Consultee Comments for Planning Application 21/00047/AAD

Application Number: 21/00047/AAD

Address: Wendover Heights Veterinary Surgery Tring Road Wendover Buckinghamshire HP22 5PN

Proposal: Additional Signage on the frontage of the property with Tring Road. Enlargement and additional signage on the surgery building.

WENDOVER HEIGHTS VETERINARY CENTRE, TRING ROAD, HALTON, BUCKS. HP22 5PN
APPLICATION FOR PROPOSED ILLUMINATED SIGN ON FRONT RIGHT SIDE OF BUILDING,
BETWEEN THE GROUND FLOOR AND FIRST FLOOR WINDOWS, TO REPLACE EXISTING SMALLER ILLUMINATED SIGN.

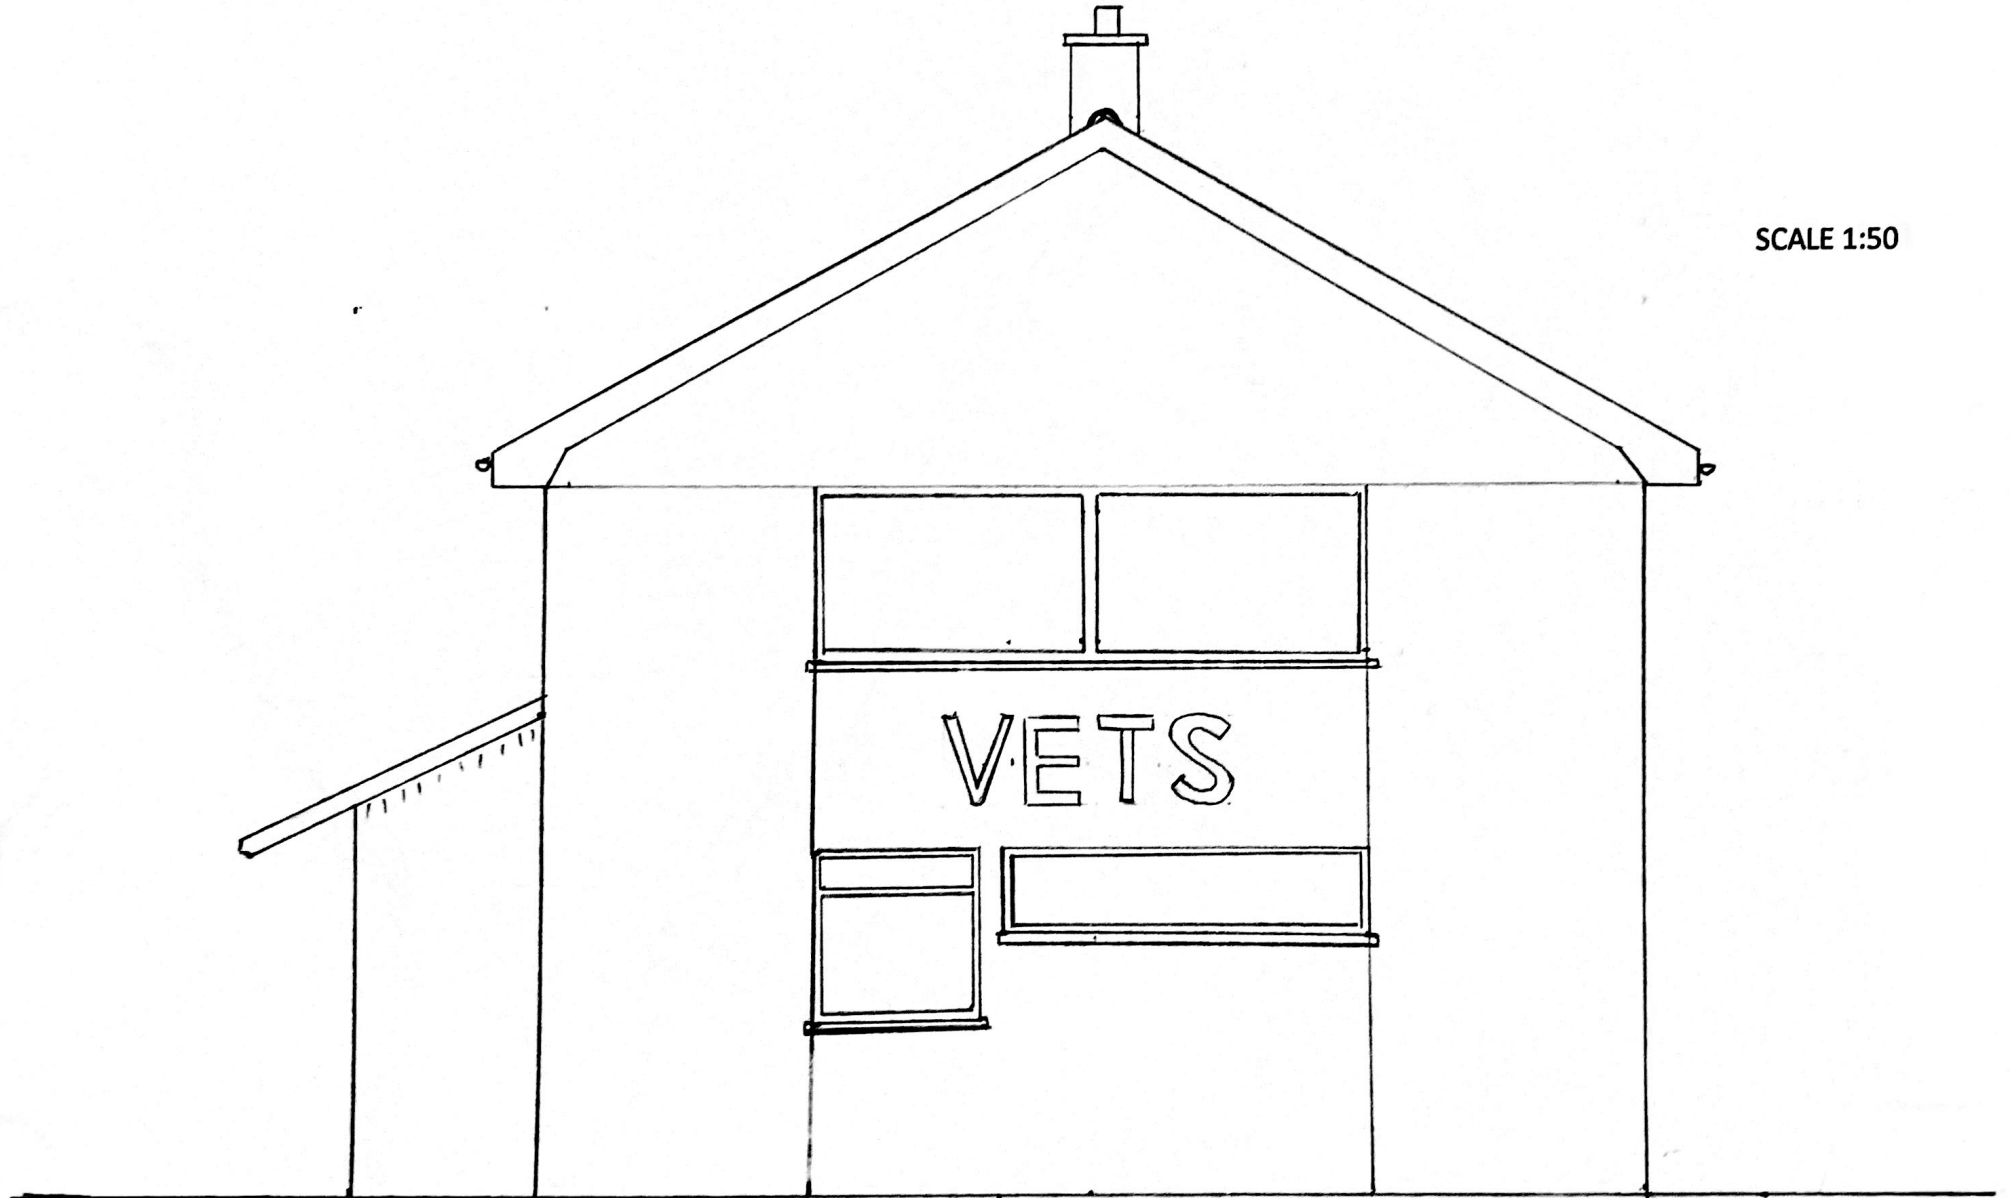
Wendover Parish Council Deferred decision. Wendover Parish Council would like to know the actual size of the proposed luminous signage on the building as there are concerns about the possible effect on the highway.
